25 February 2022

BOWMANS CREEK WIND FARM (SSD-10315)

This letter has been prepared to provide further information and respond to recommendations, as requested by DPE, Heritage NSW and BCD.

**FIGURE 1**

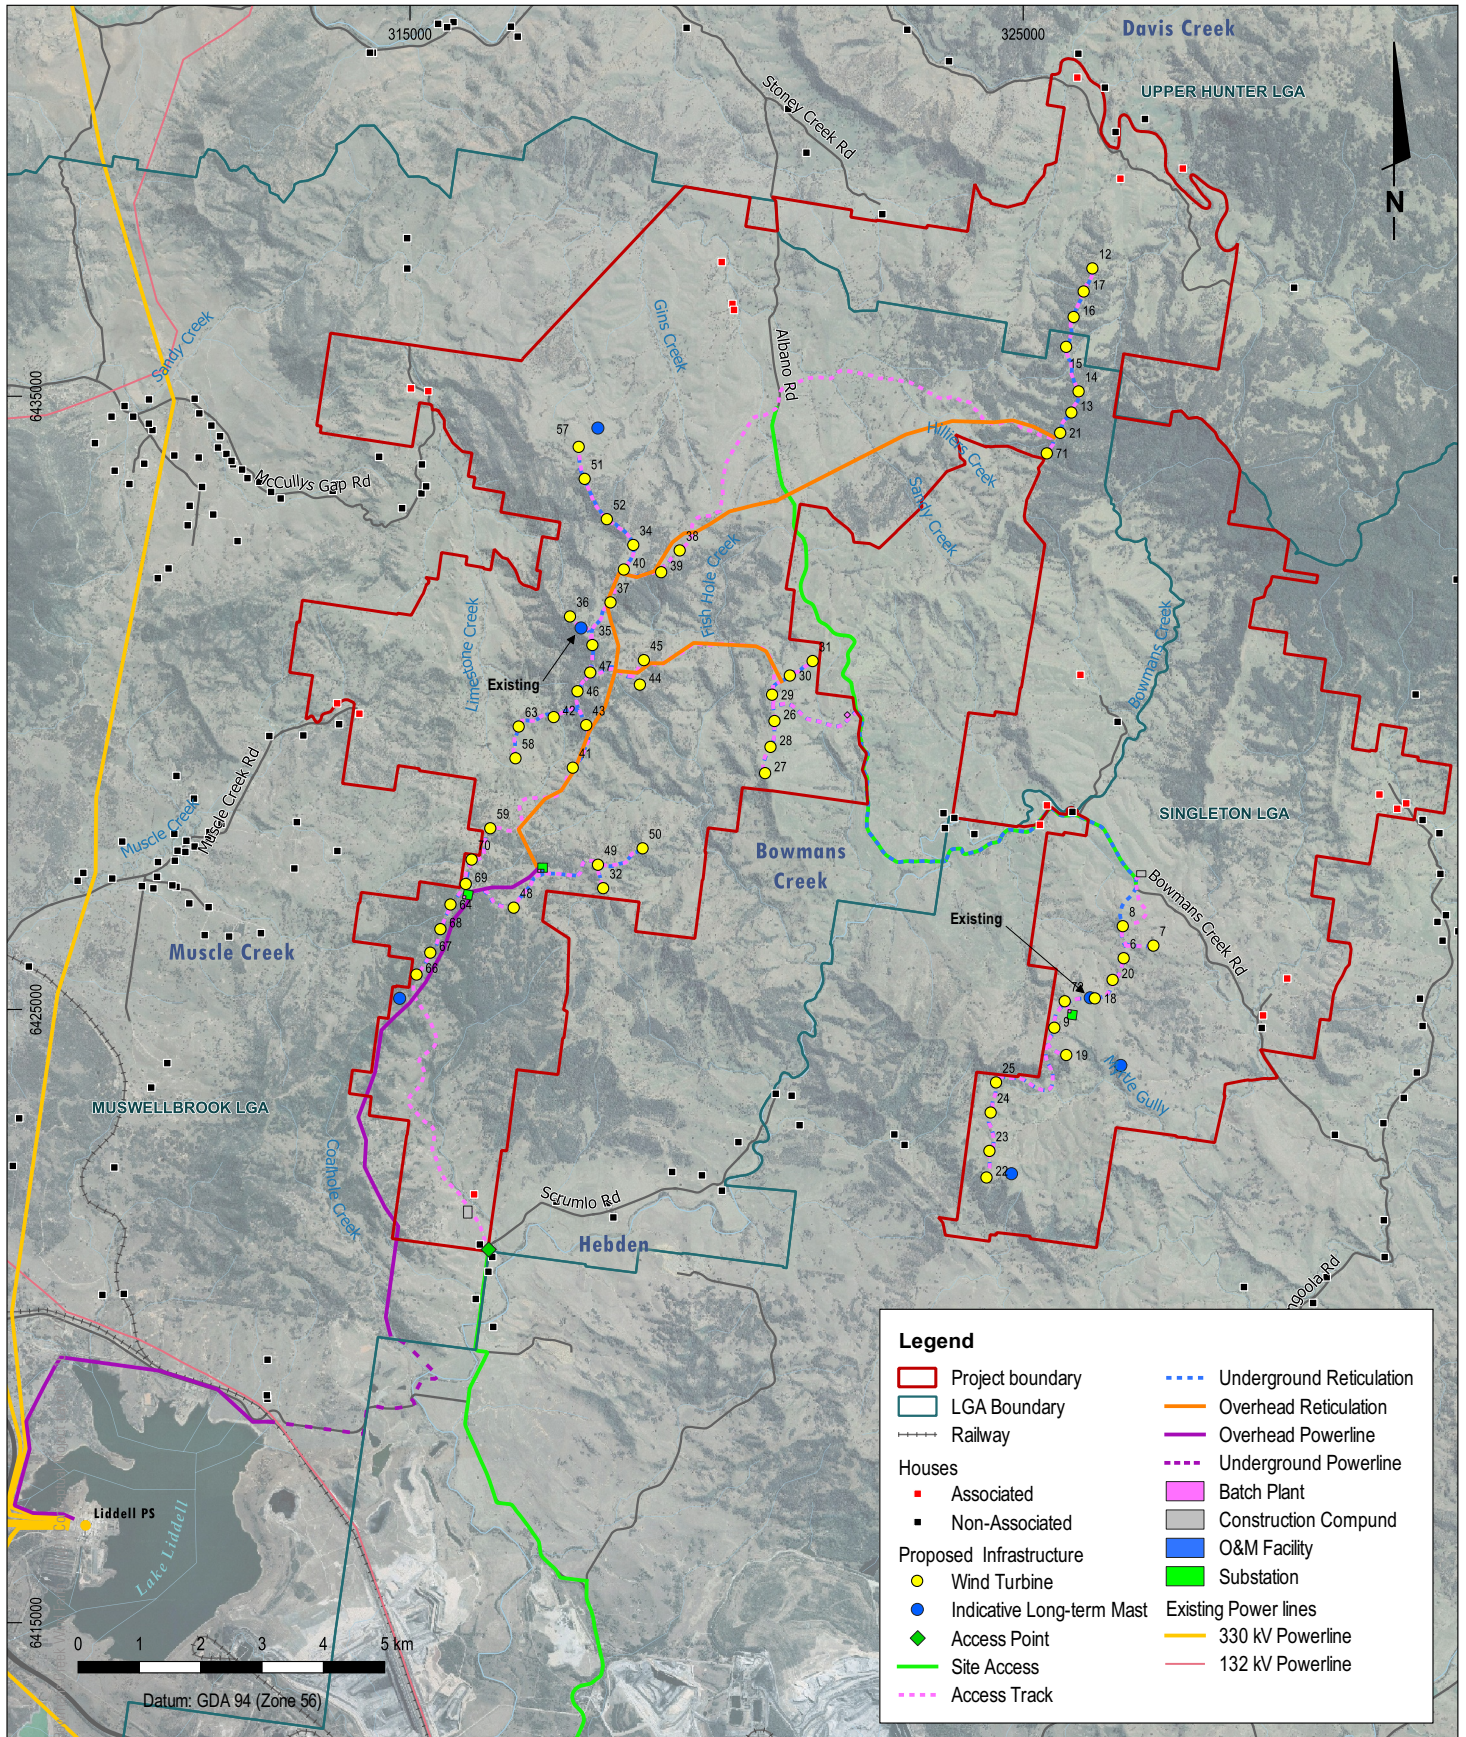
- *Regional Context (EIS Figure 2) and Project Layout (Amendment Report Figure 2): Increase clarity and include key features, including satellite imagery, major roads, associated / non-associated residences; railways; waterways/creek lines; internal and access route roads;*
- *Road Upgrades: Provide an overview (regional scale) map of proposed road works, with location of works marked and cross referenced with the agreed schedule of works;*
- *Heritage: Provide a consolidated Archaeology and Cultural Heritage (ACH) and Historic heritage figure showing the amended project layout, including:*
 - *Historic heritage sites (3 LEP listed sites, 2 new sites); and*
 - *Aboriginal heritage sites identified during surveys and the three AHIMS sites within the Survey area (ensure sites are identified).*

Update figures are provided in **Appendix E**.
